# The Planning Inspectorate Yr Arolygiaeth Gynllunio

Our Ref: EN010112

### **Application by Awel y Môr Offshore Wind Farm Limited for an Order Granting Development Consent for the Awel y Môr Offshore Wind Farm**

#### **Advice following issue of decision to accept the application for examination**

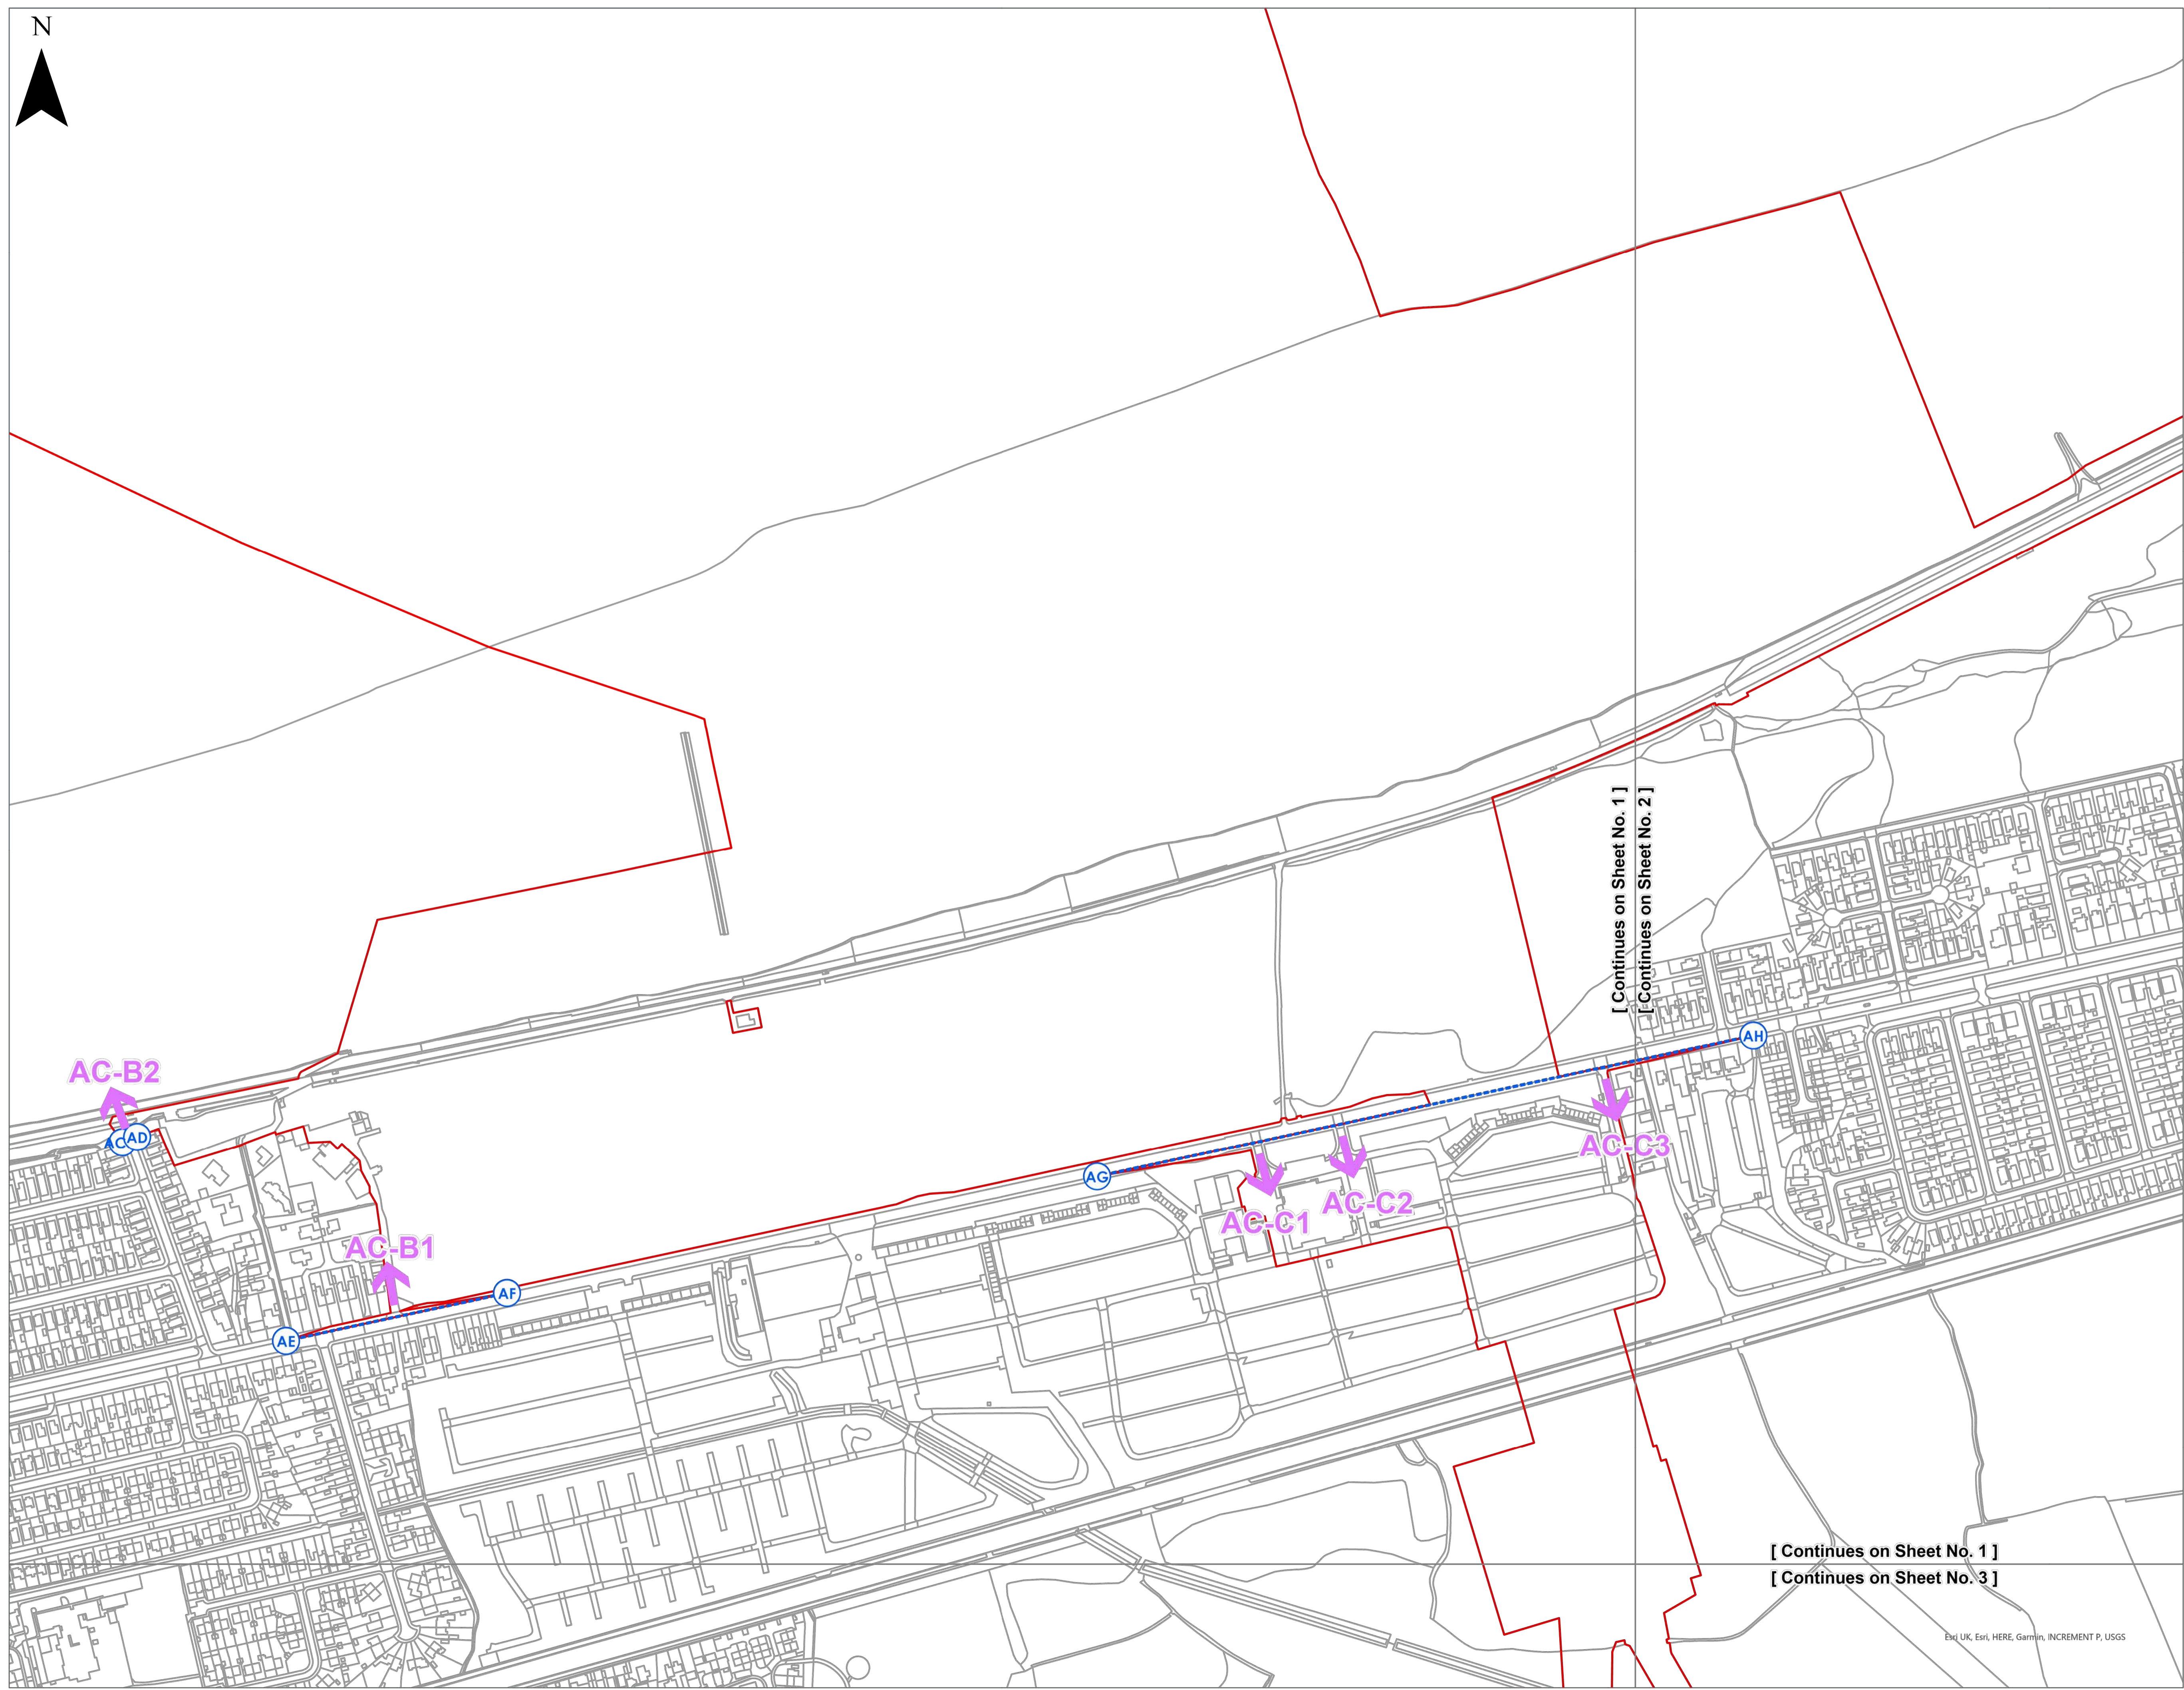
- The legend in the Street Works and Access Plan refers to Schedule 4 instead of Schedule 3 of the dDCO.
- Footpath names on the Temporary Stopping Up of Public Rights of Way Plans could be enlarged.

- Schedule 3 – points BI and BJ shown on the last page of the street works and access plan have been omitted.
- Schedule 4, columns 1 and 2 – inconsistencies between the information in these columns and the information shown on the temporary stopping up of public rights of way plan, and the naming of the plan is the 'temporary stopping up of public rights of way plan'.

- Schedule 5, column 1 – References to AC-Q do not appear on the street works and access plans. 'AC-Q1' and 'AC-Q2' appear on the plans but are omitted from Schedule 5. It would also be helpful to identify the relevant sheet numbers.
